19th January 2022

NSW Department of Planning, Industry and Environment
12 Darcy Street
Parramatta NSW 2150

**R4A Residential Building (SSD-6964) Mod-5
Request for additional information
Barangaroo South**

R4A  
SETOUT PLAN BASEMENT LEVEL B2

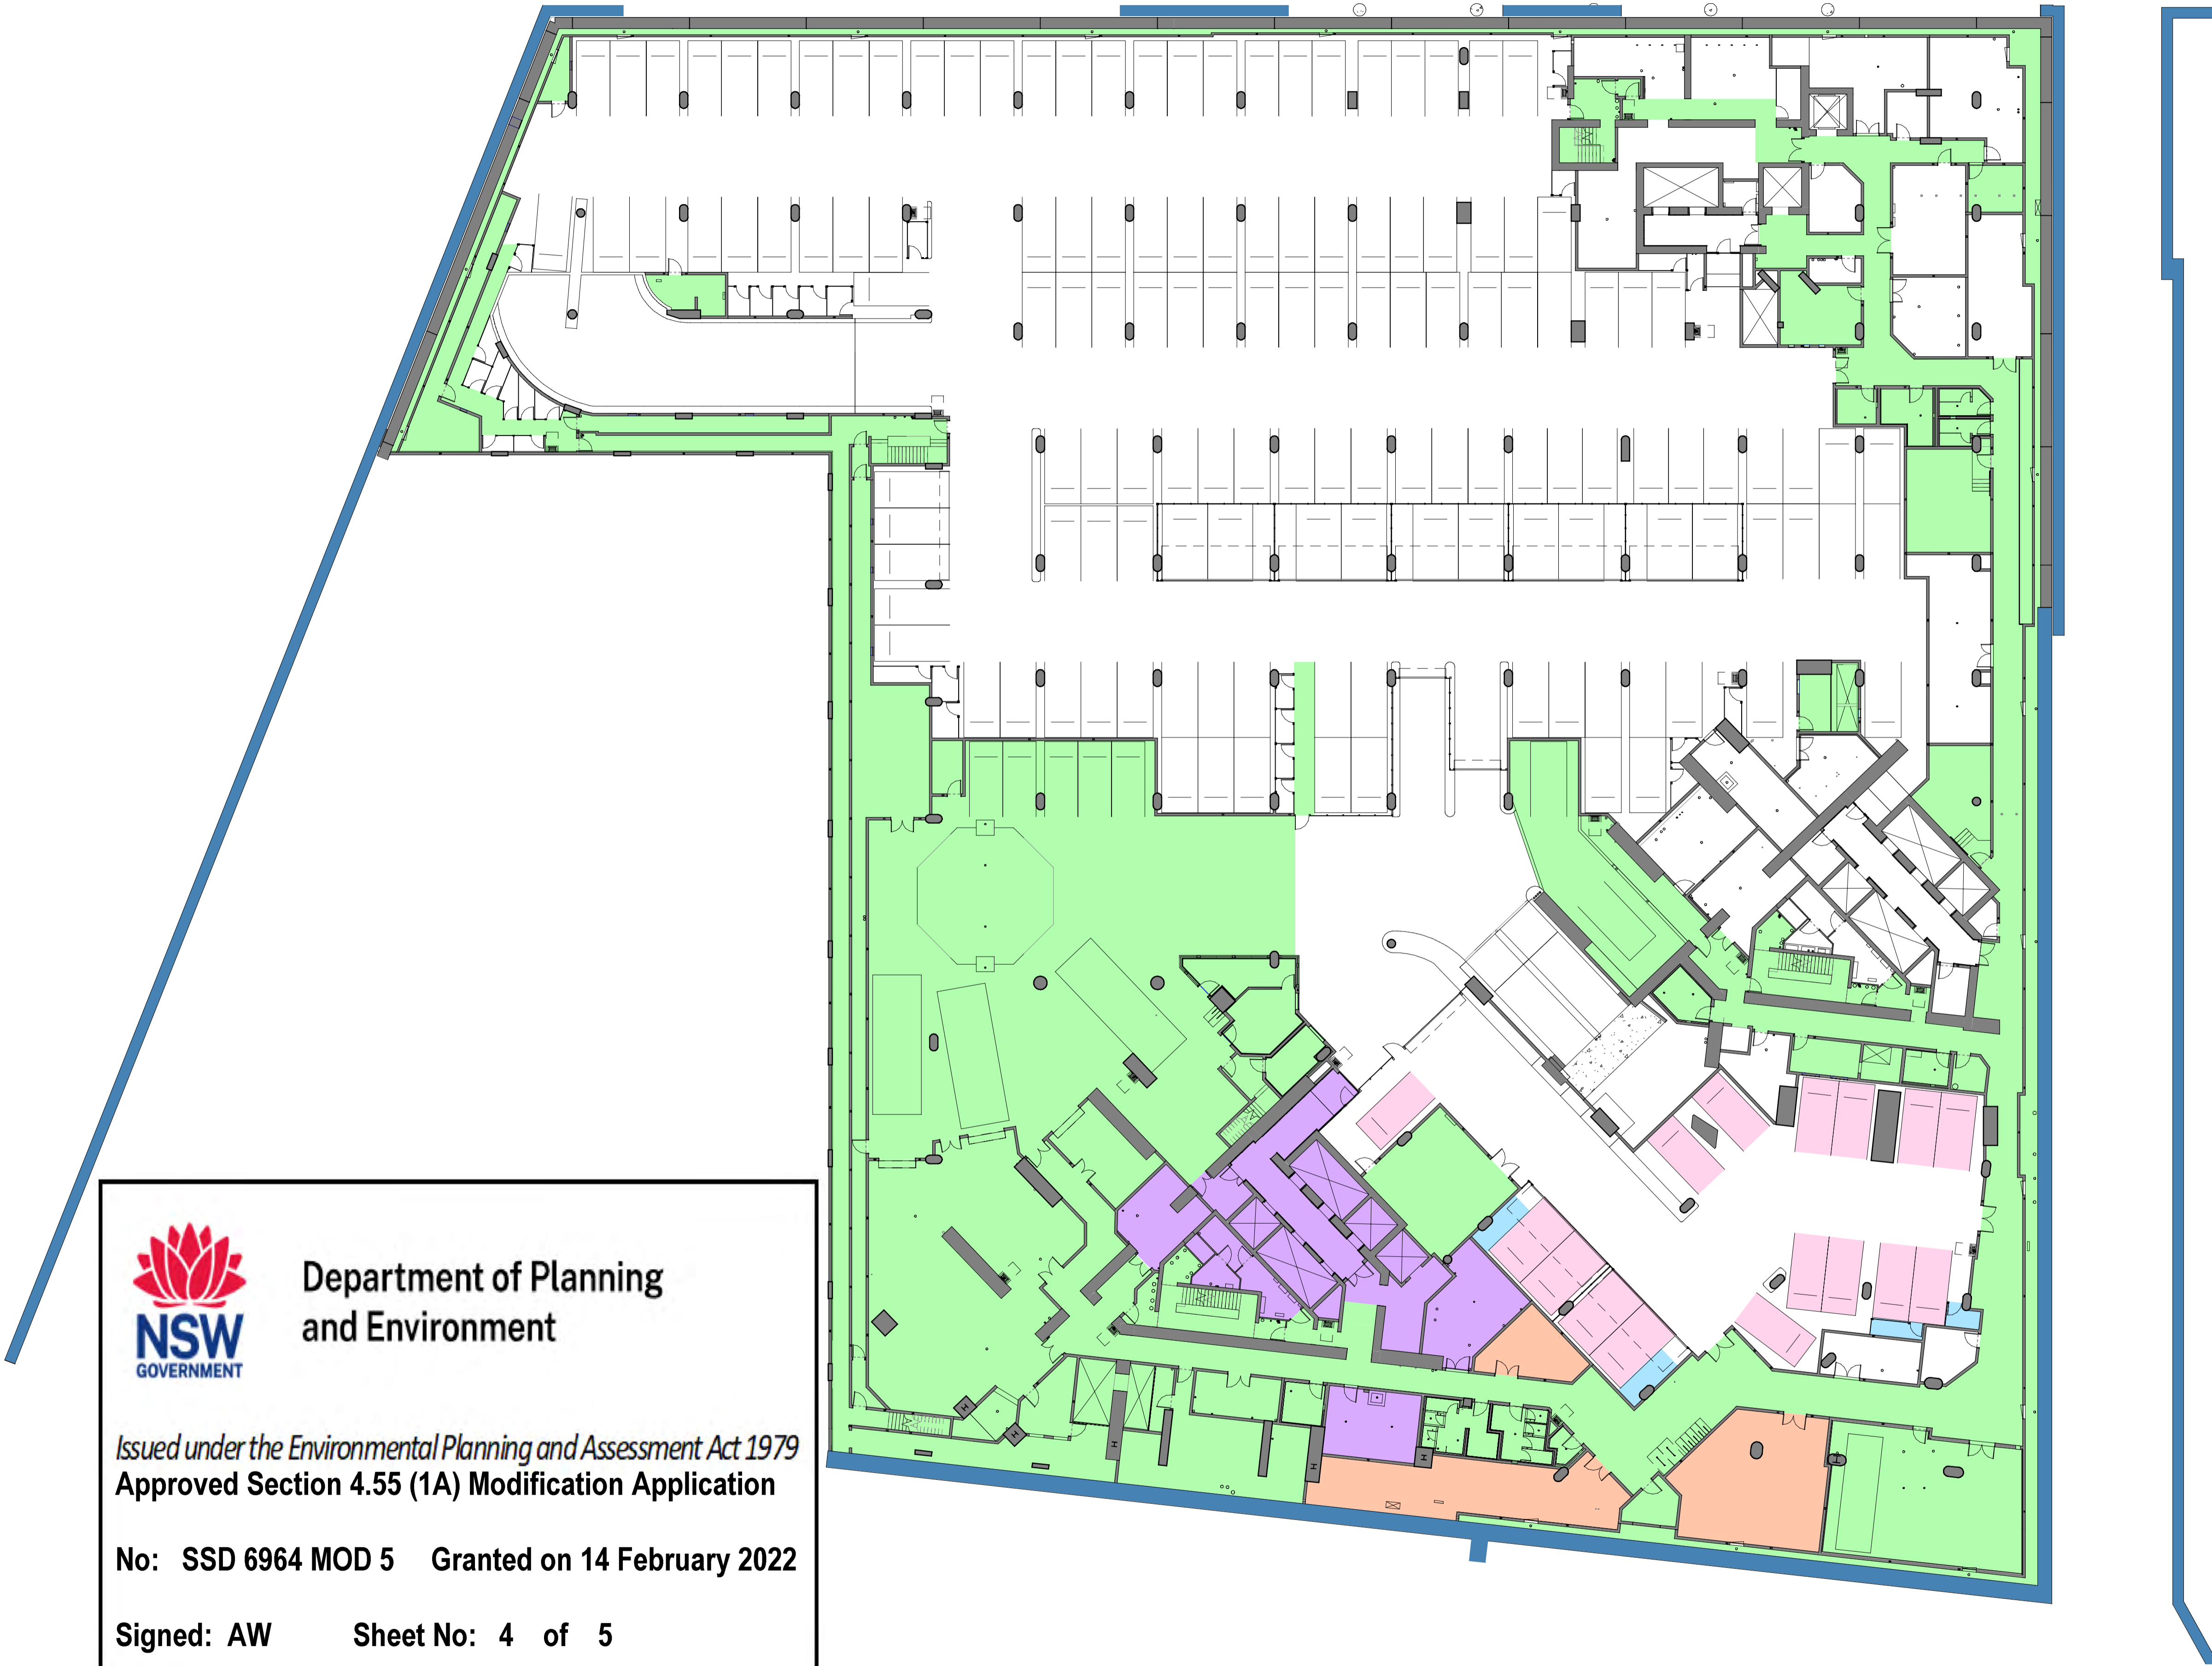
Confirm the reallocation of storage cages between Building R4A and R5 on Level B2, noting the modification report for R4A describes the proposed change as:

Removal of two storage cages and addition of one storage cage within a garage at the rear.

where as the plans for R4A (Drawing No BR4A_ASD_PA1_1003 Set out Plan Basement Level B2 dated 21.10.21) show:

- 1. Storage cage reallocation in the north-west corner of the basement (annotated 4) which appears to be two spaces reduced to one*
- 2. Three storage cages allocated to R4A from R5 in the north-east corner of the basement (annotated 3)*
- 3. Two storage cages allocated to R5 from R4A in the south-east corner of the basement (annotated 5)*

Confirm if there is an overall increase/decrease or no change to storage cages for R4A and R5.

1. There is a proposed storage cage reallocation in the north-west corner of the basement (areas annotated item 4 on the drawings) which is the removal of two storage cages and addition of one storage cage within the garage at the rear. Refer to Figure 1 below.

2. Three storage cages would be allocated to R4A from R5 in the north-east corner of the basement (annotated 3 on the drawings), refer to Figure 2 below.
3. Two storage cages would be allocated to R5 from R4A in the south-east corner of the basement (annotated 5 on the drawings), refer to Figure 2 below.

The reallocation of storage cages between R4A and R5 is required to accompany the proposed reallocation of car spaces between R4A and R5. This is due to the access for these storage cages being through/near the proposed reallocated car spaces. Therefore, the reallocation supports their spatial distribution per the subject building area in the basement.

- With respect to R4A, whilst item 1 above is a decrease of one storage cage for R4A. Item 2 and 3 results in an increase of one storage cage for R4A. Accordingly there is no change to the final number of storage cages for R4A through the reallocation process.
- With respect to R5, under the modification application(s) there are three storage cages allocated to R4A from R5, and two storage cages allocated to R5 from R4A. This represents an increase of one storage cage for R4A and therefore a decrease of one storage cage for R5. This change however has no impact on the adequate provision of storage space for the R5 apartments, where there is already sufficient storage capacity to meet the objectives and provisions of the Apartment Design Guide through cages and (or) internal storage areas per apartment typology.
